DRB Application No.: 03-00302 (SBP)	Project # 1002507
Project Name: ALAMEDA BUS. PK LOT 43	EPC Application No.:
Agent: Sanders & Associates Architects	Phone No.: 842-8413

**CITY OF ALBUQUERQUE
PLANNING DEPARTMENT
Development Review Board
3/12/03 Comments**

Subject: Alameda Business Park, Lot 43/SBP

1 NORTH ELEVATION
SCALE: 1/8" = 1'-0"

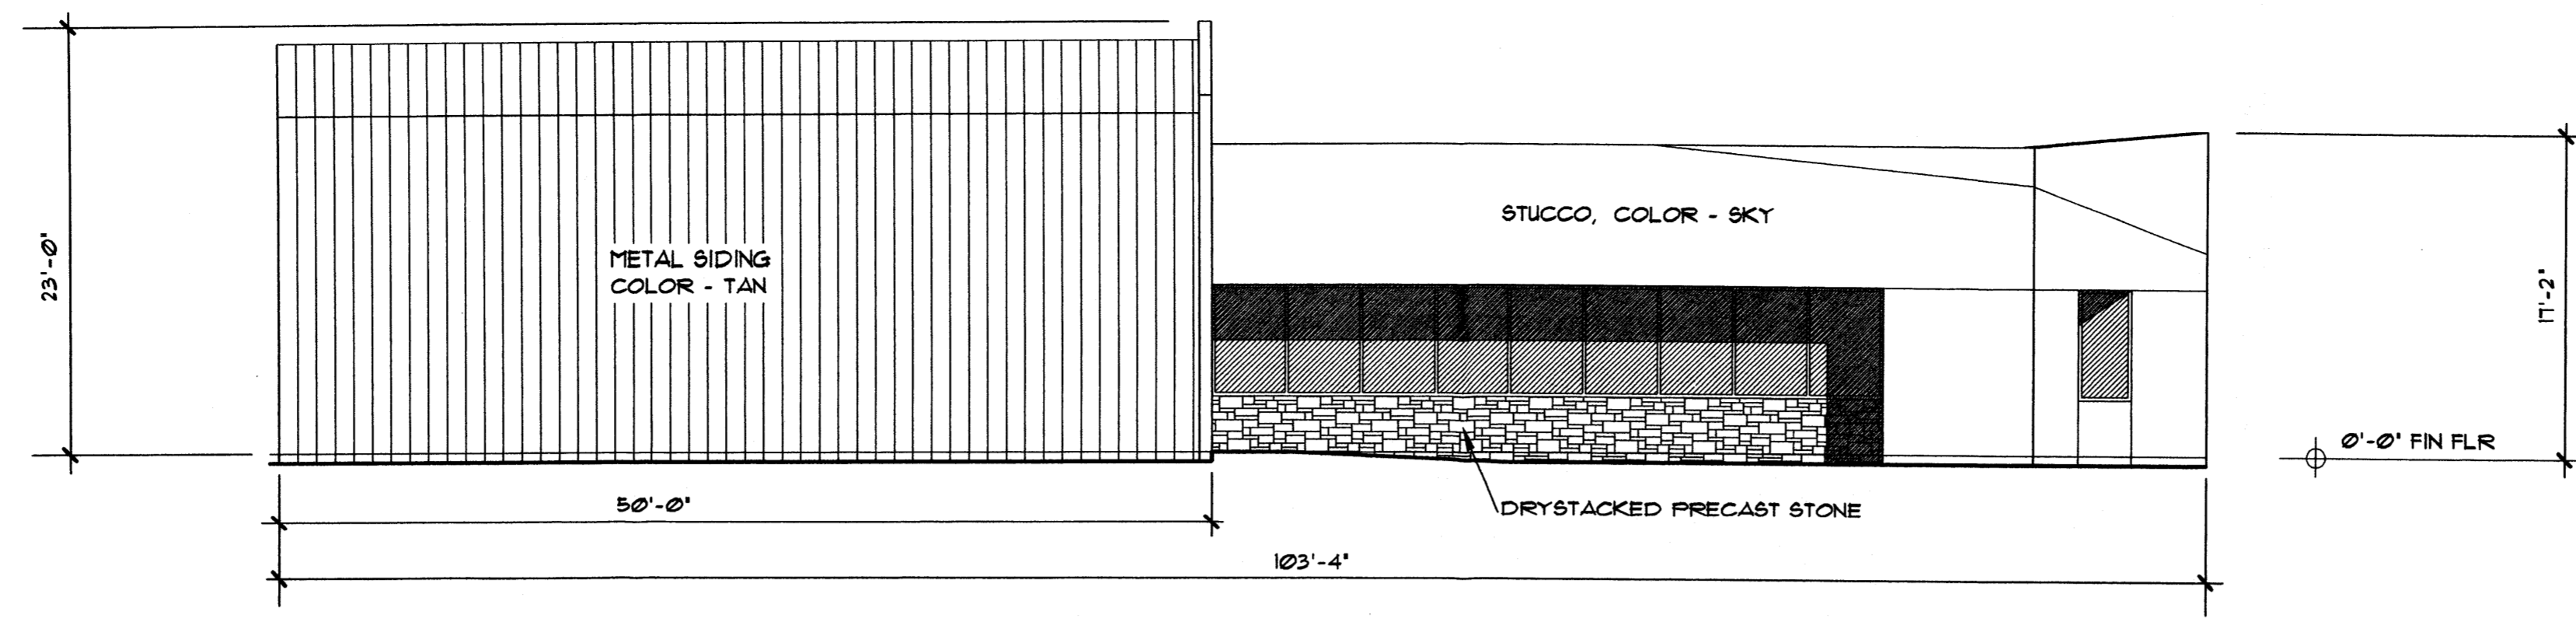
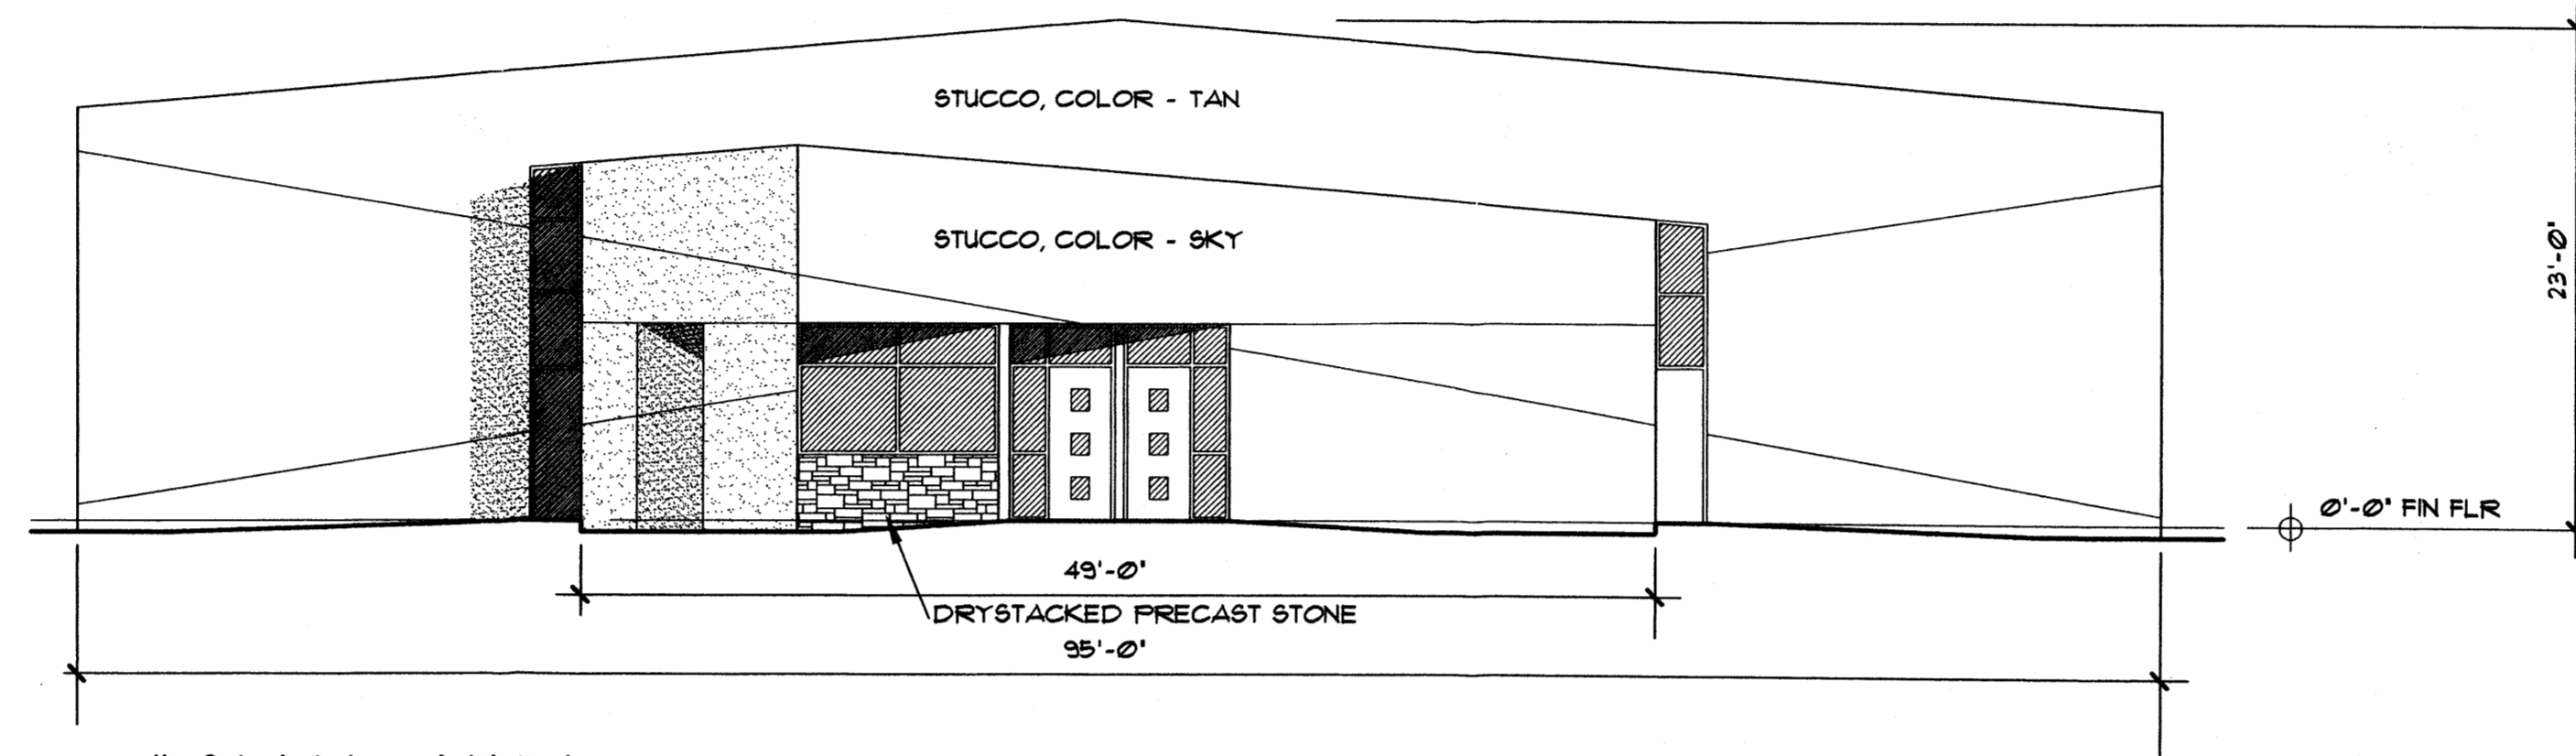
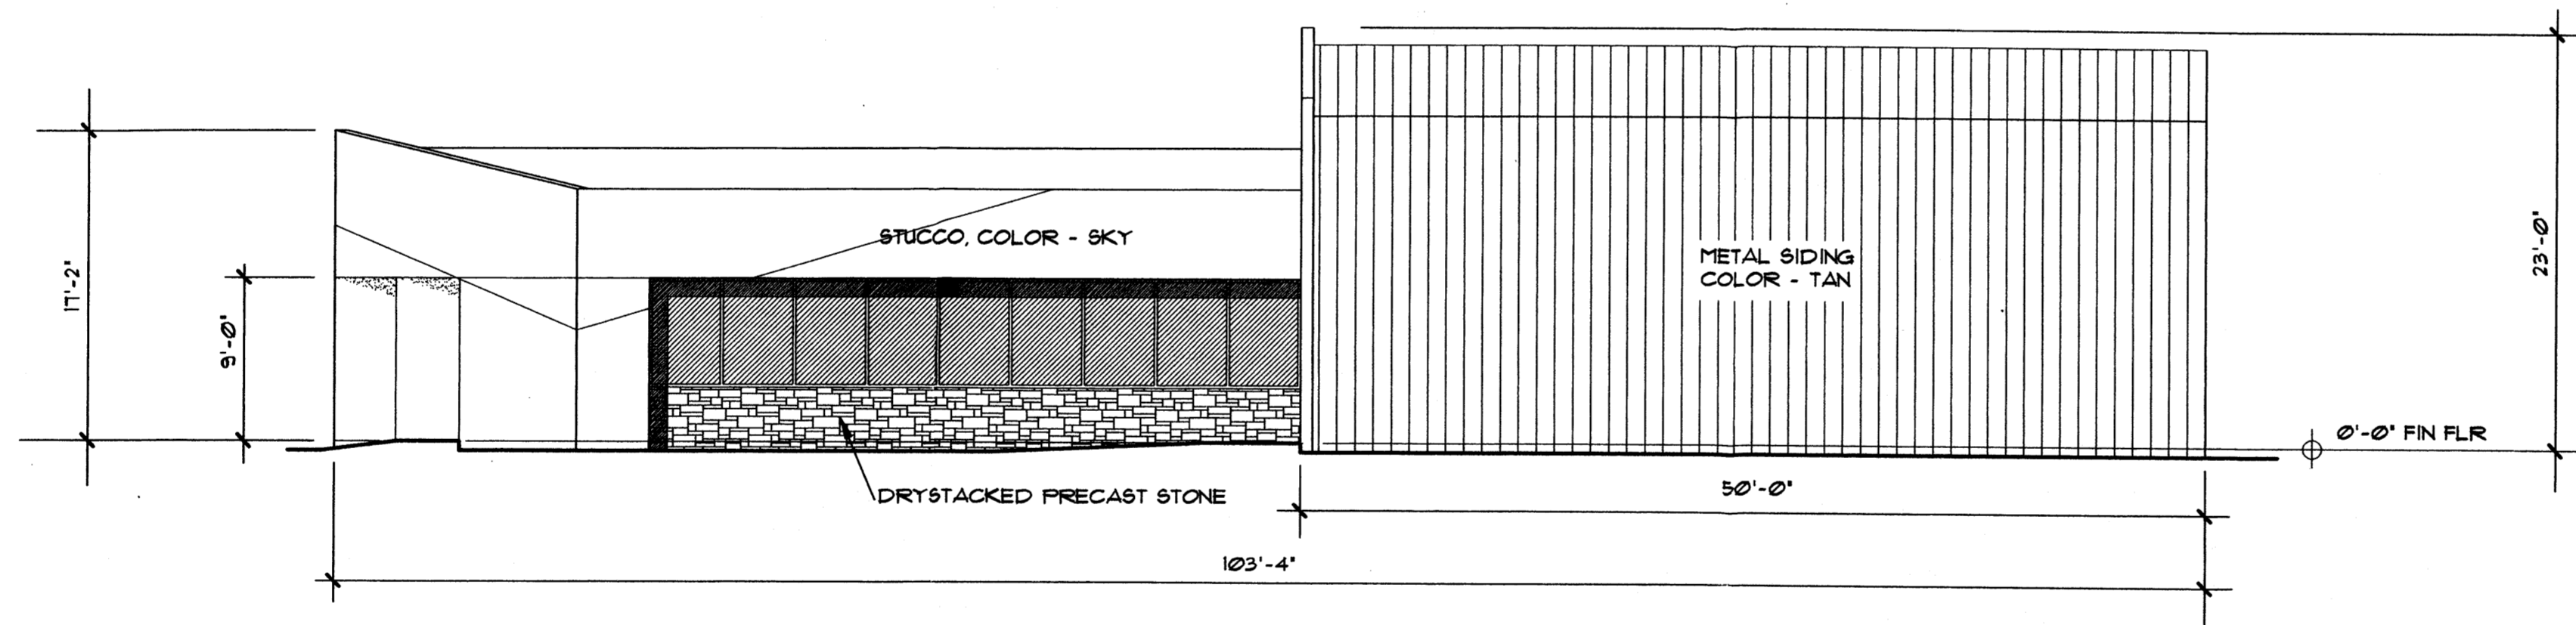
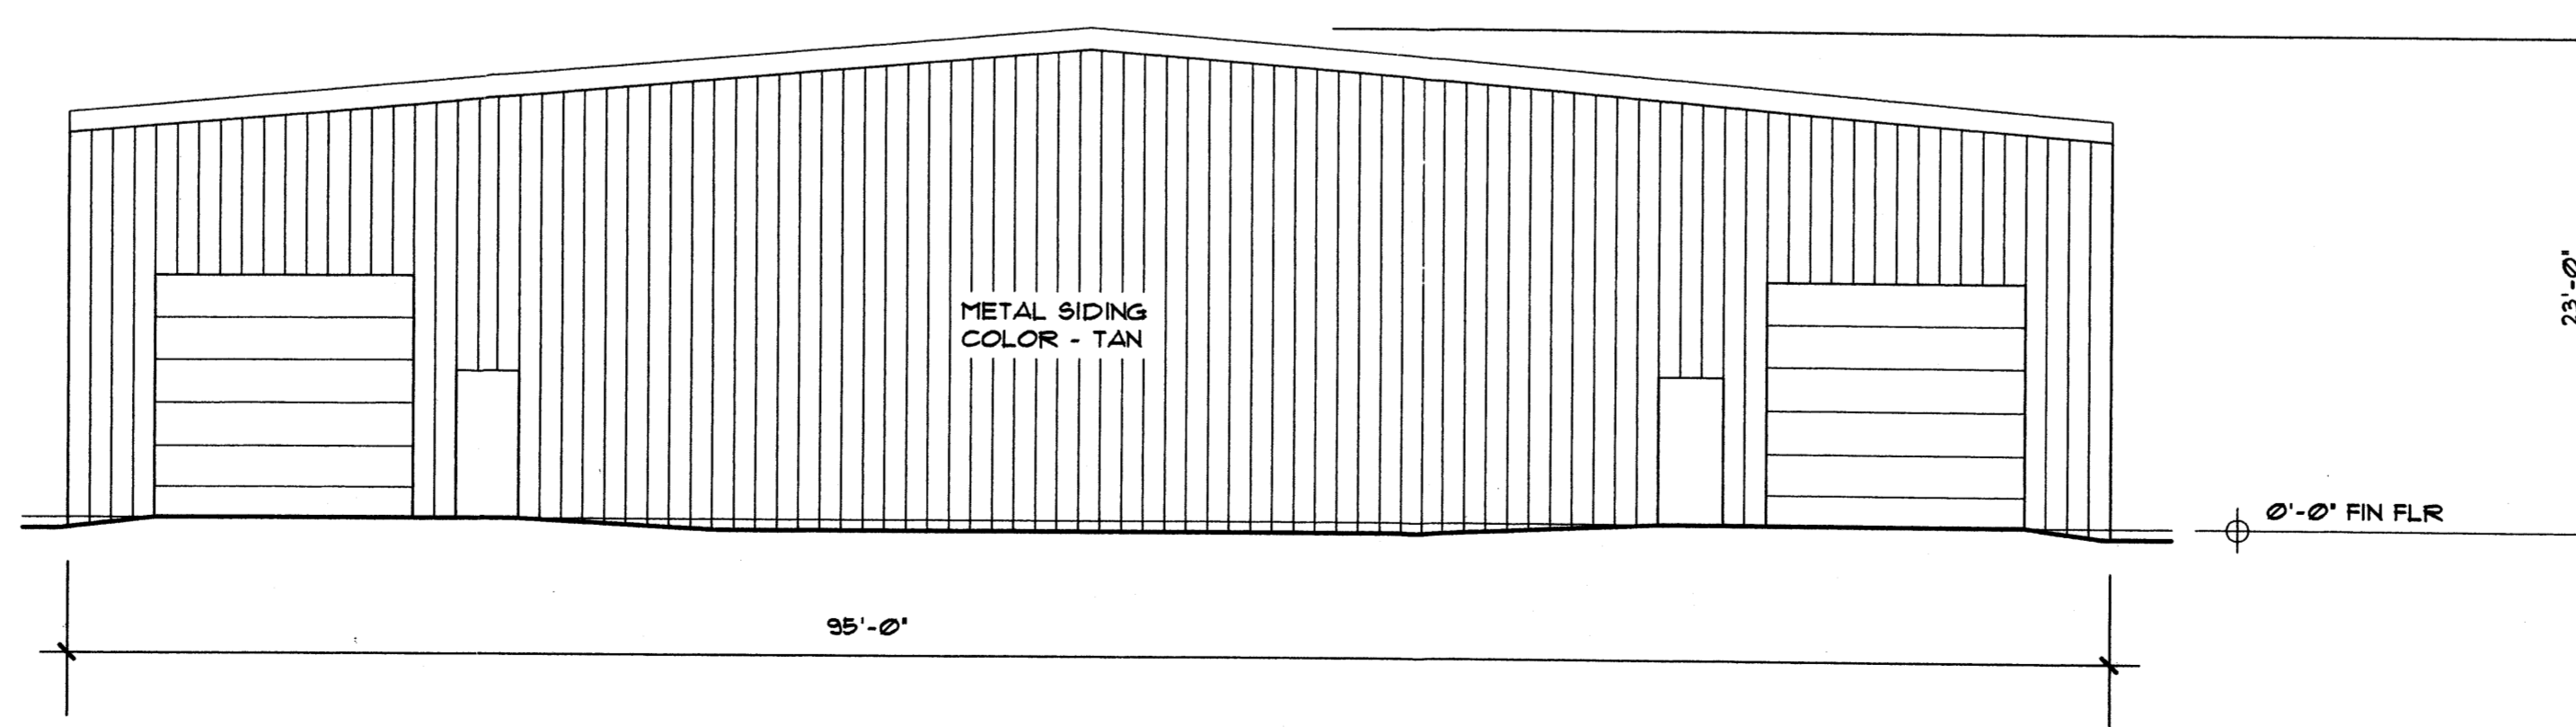
Materials and colors for the pitched roofs are to appear on the elevations page per the Master Plan.

Signs are not shown on the elevations page or the site plan. Signs should be shown and conform to the Master Plan requirements.
